Northern Beaches Hospital SSI Application SSI 13_5982

Submissions Report/Preferred Infrastructure Report

February 2014

Noise Monitoring Data

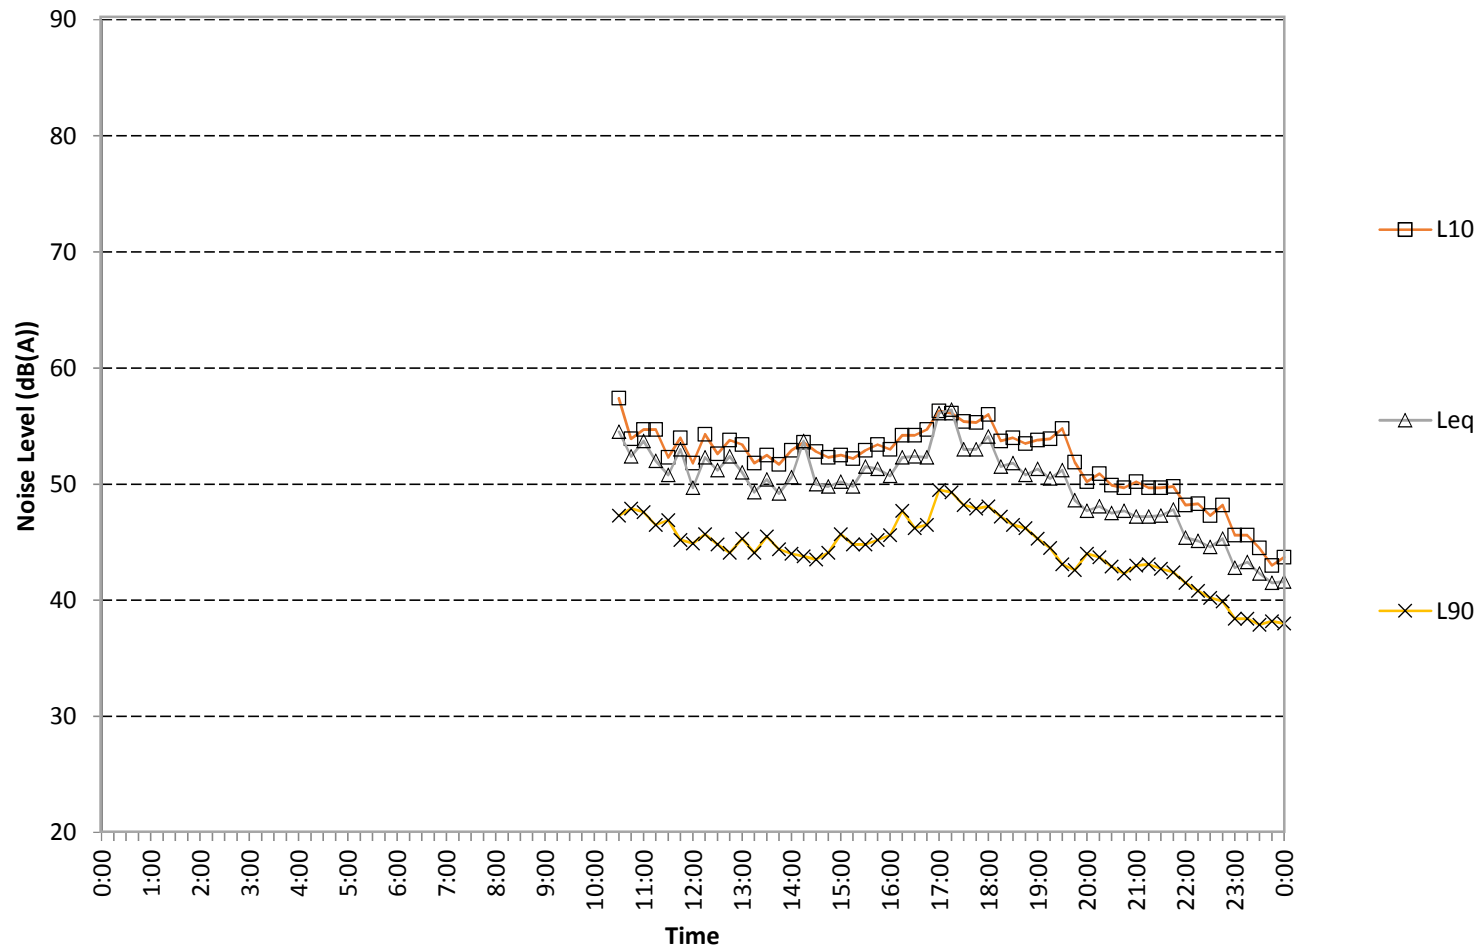
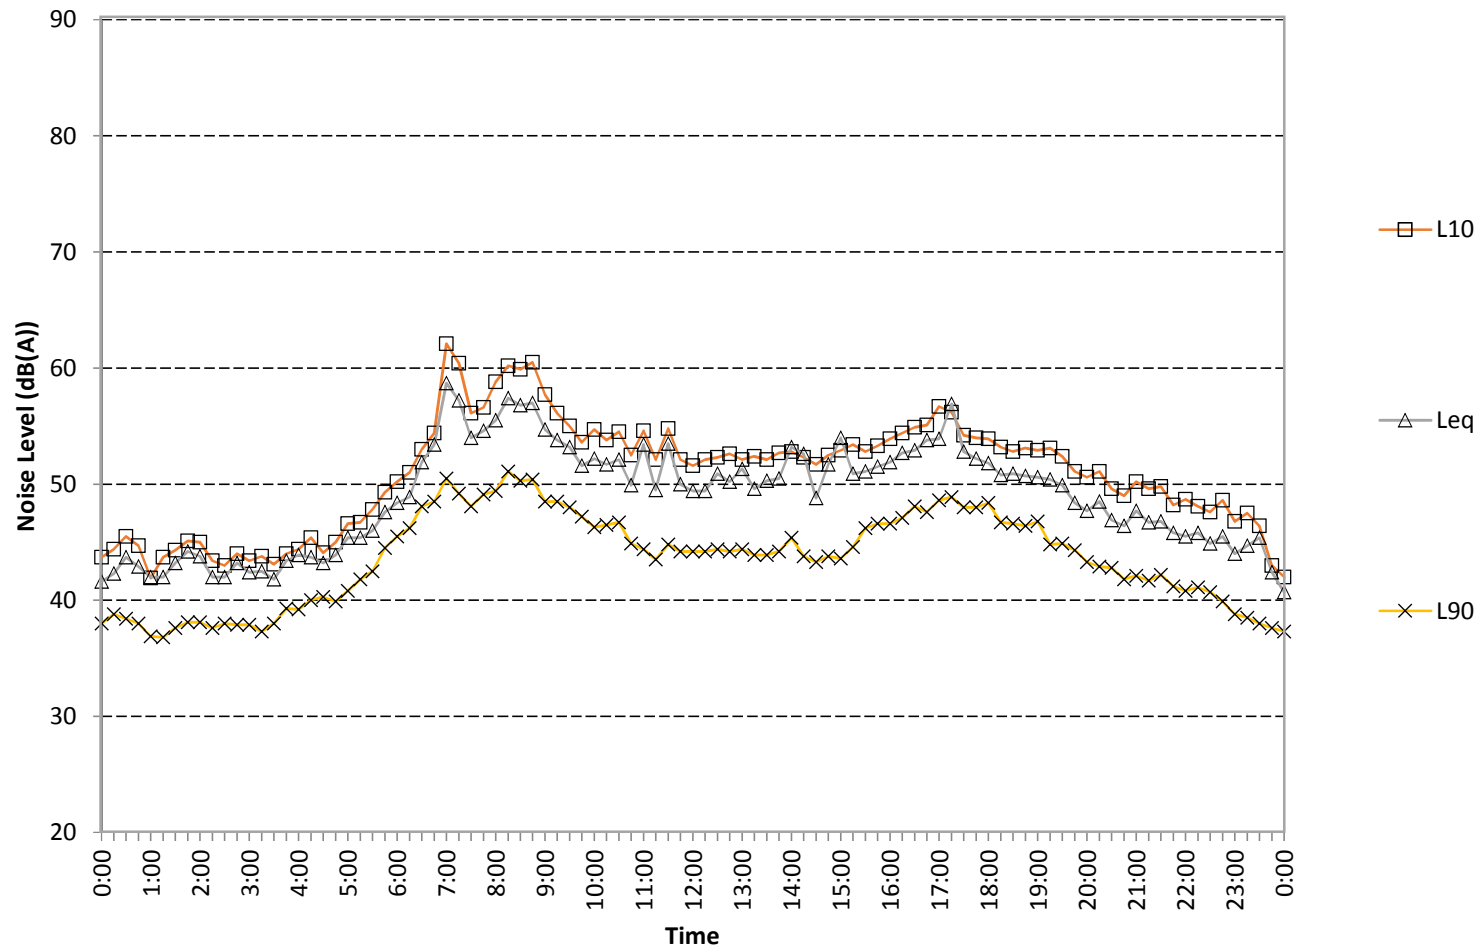
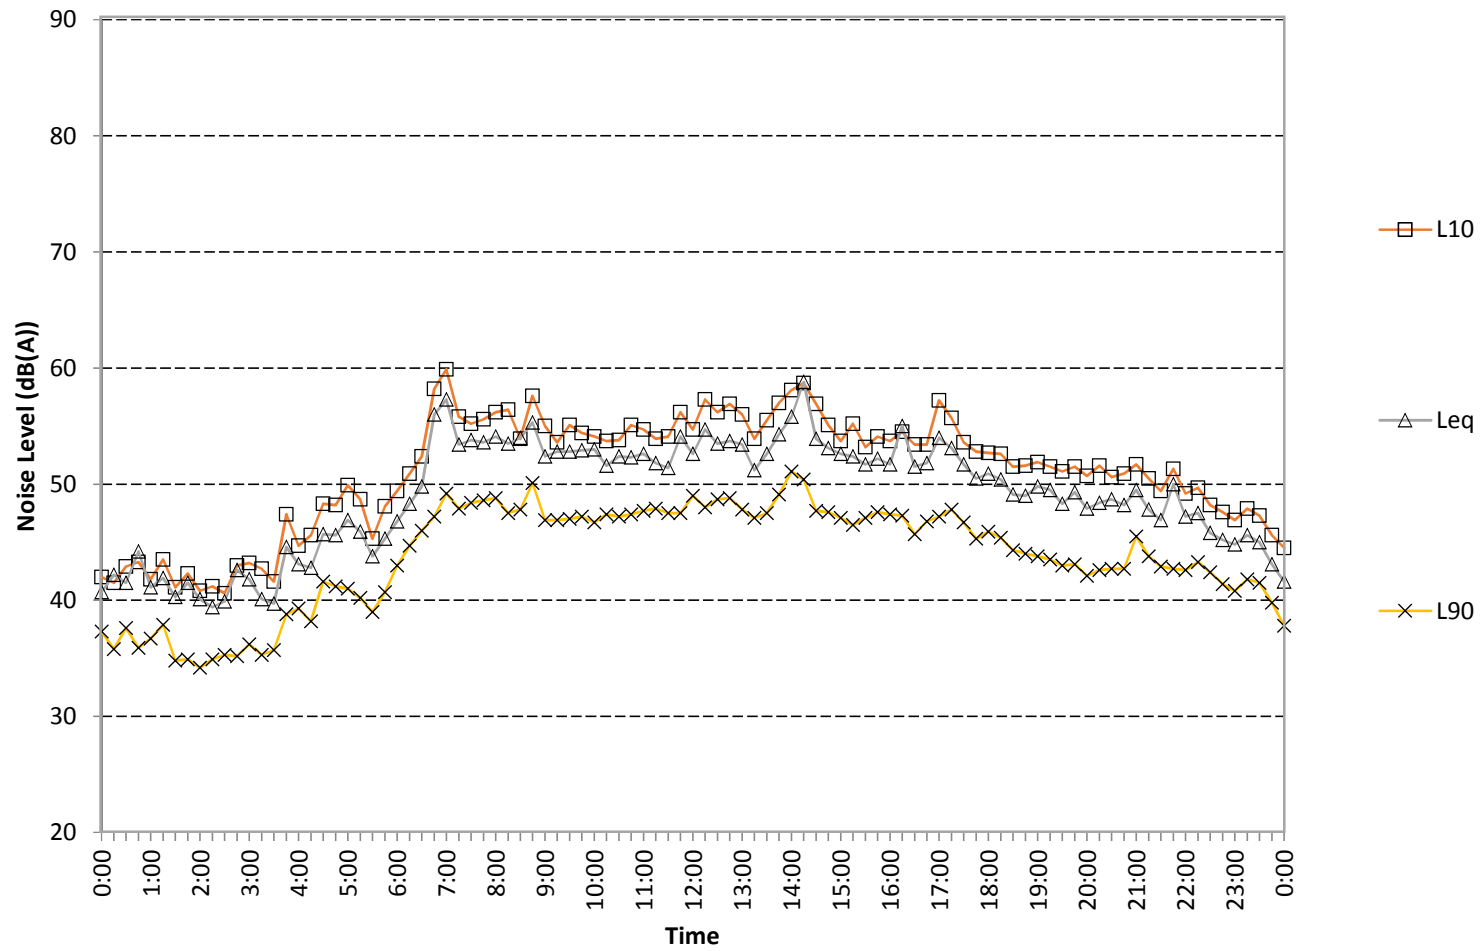
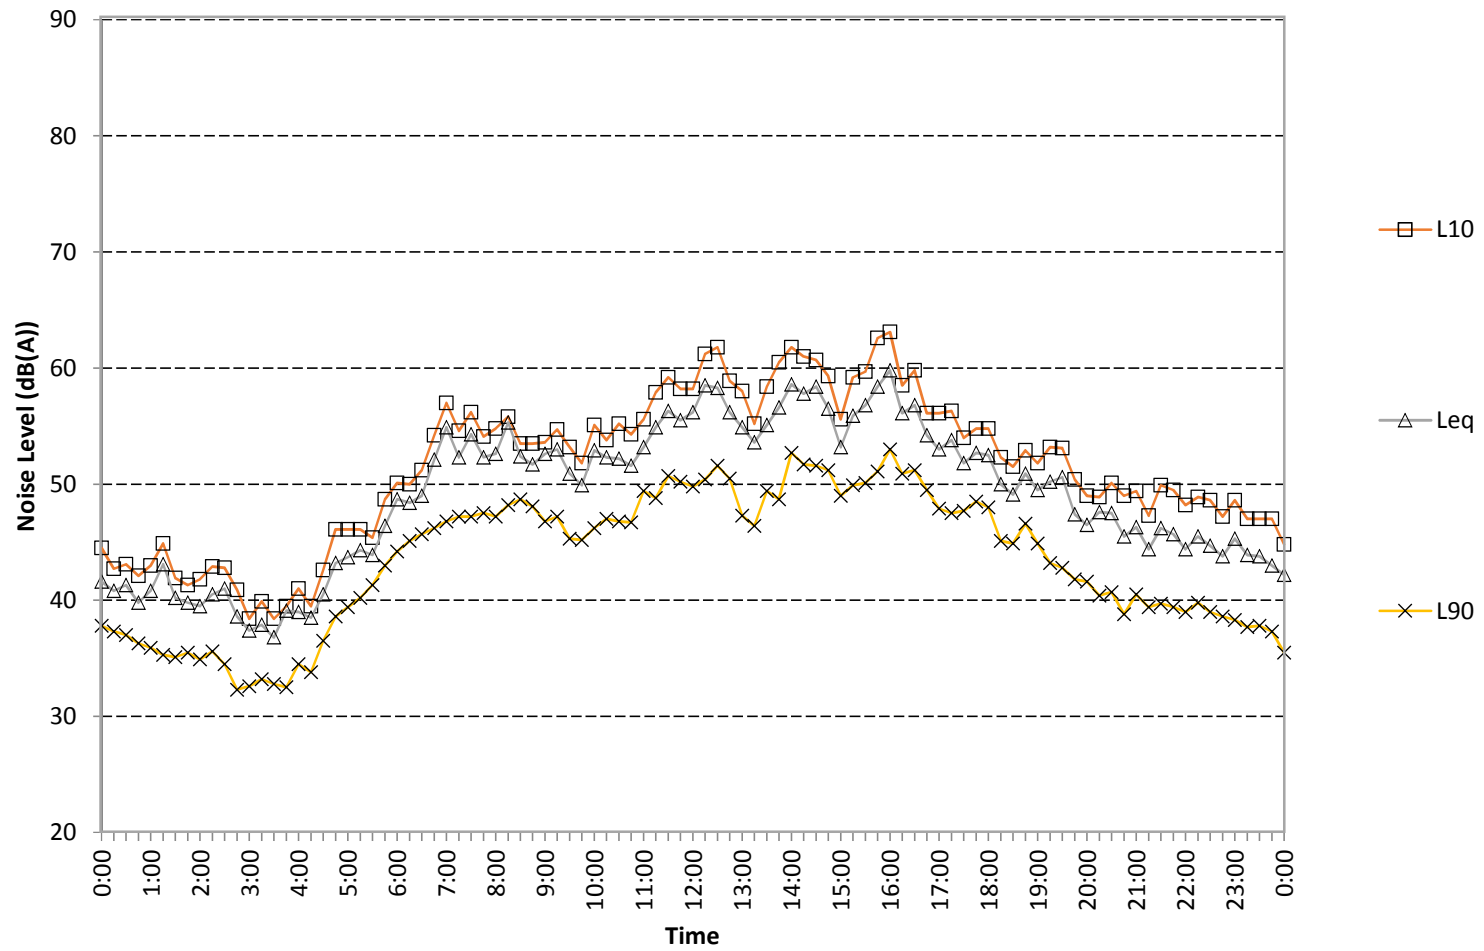
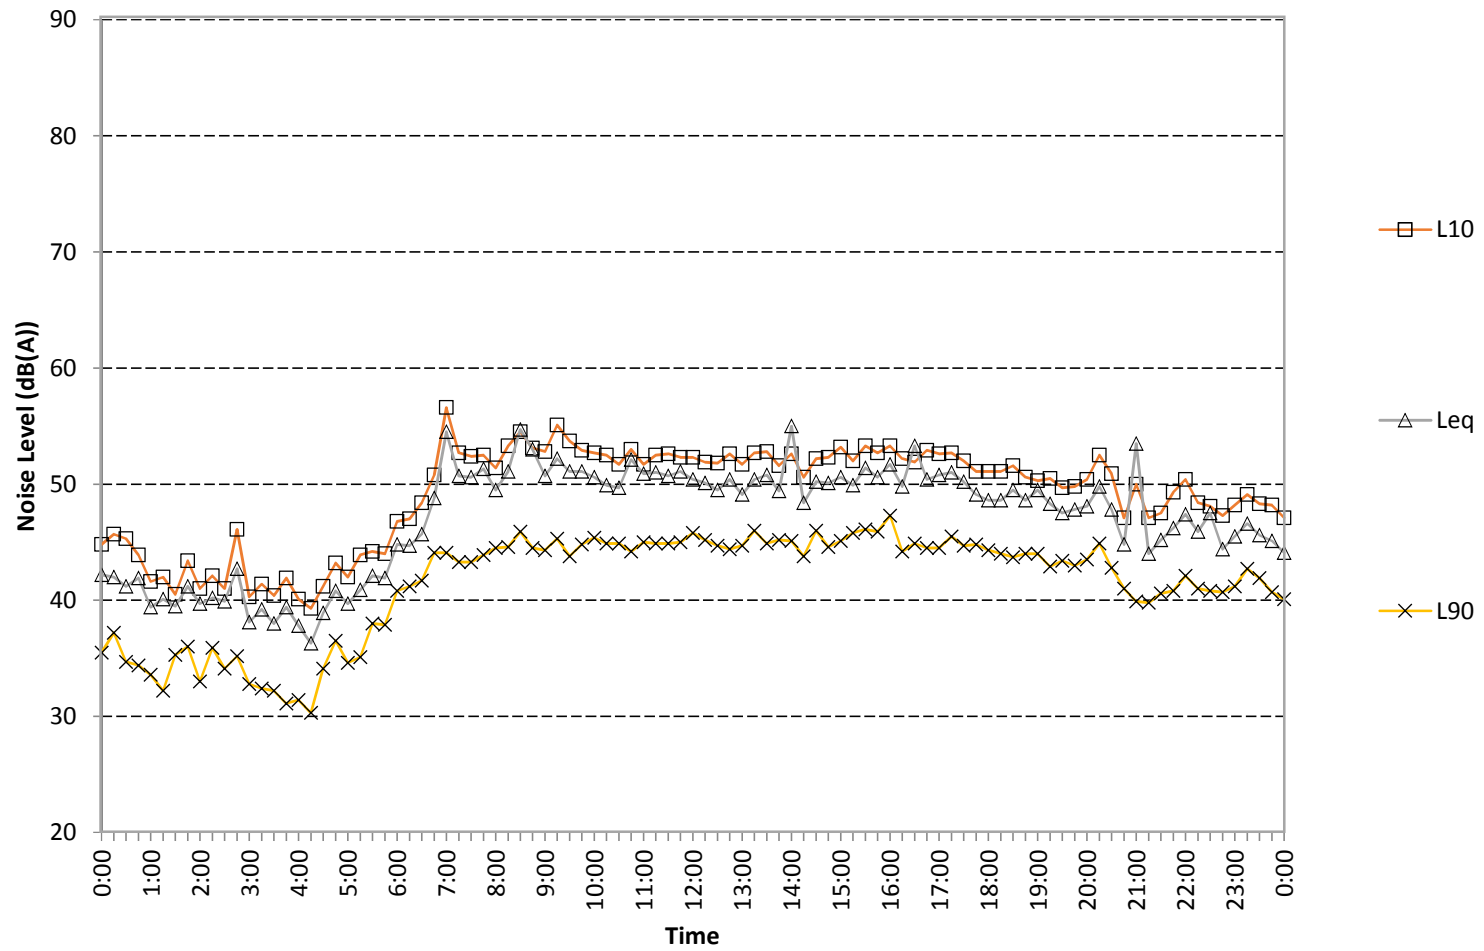
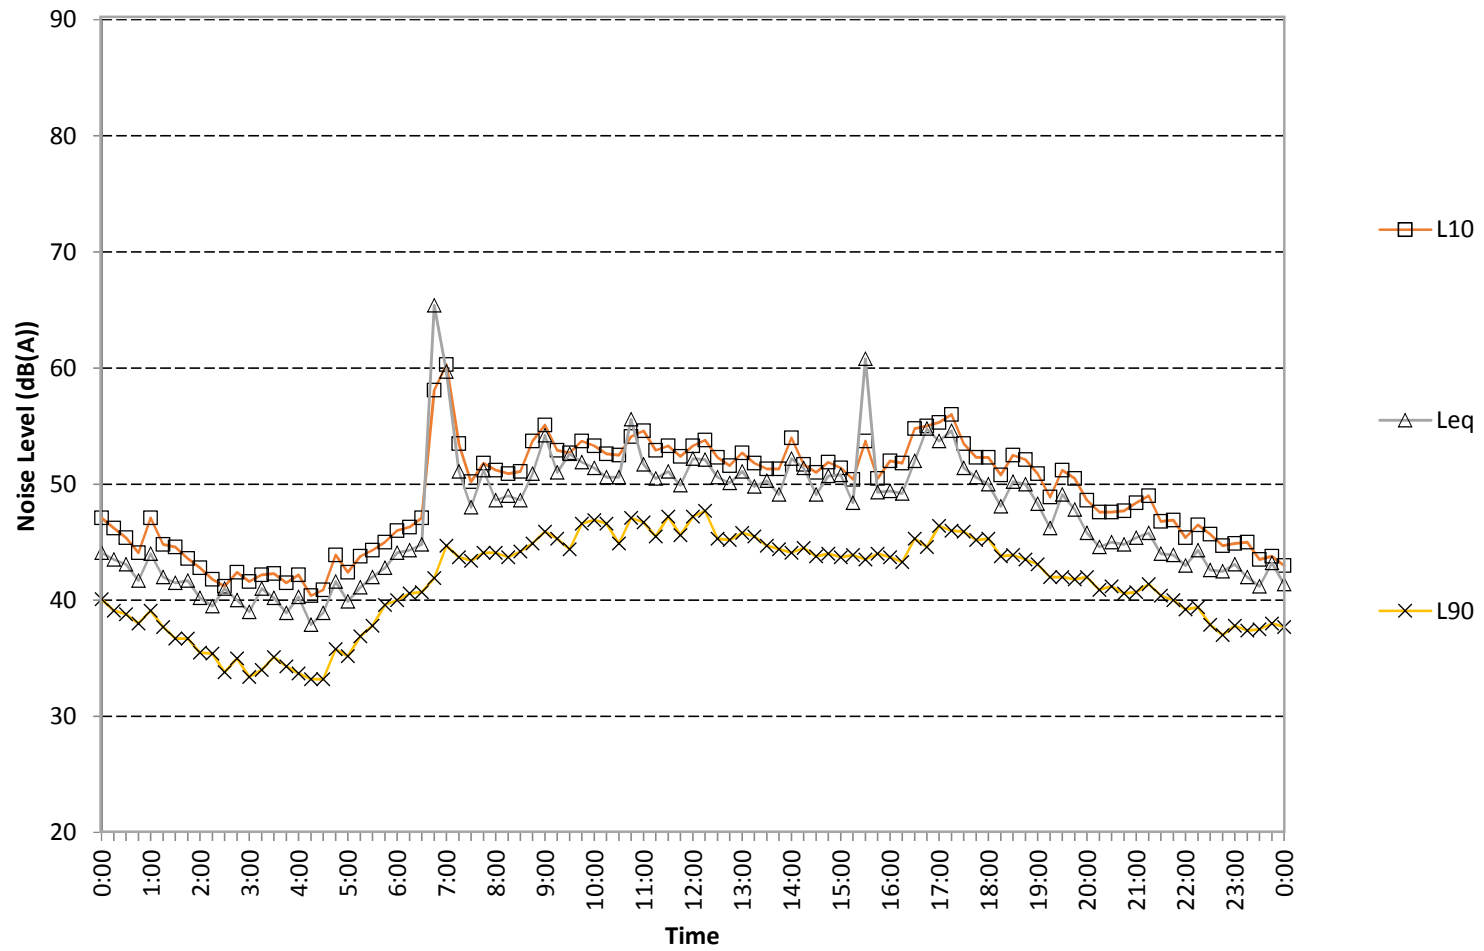
25. Background noise levels in Table 1 in Appendix K.	<p>There is a transposition error in the table. The noise levels for logger A should be against logger B and vice versa. There is a similar transposition error in Table 2 with respect to the noise-affected levels for residences on Frenchs Forest Road West and Warringah Road.</p> <p>These transposition errors have not affected the analysis, nor the conclusions drawn.</p> <p>Amended versions of these two tables are provided in Section 3.3 of this report. Background noise levels and noise criteria for periods outside of the recommended standard construction hours have also been included for completeness.</p>
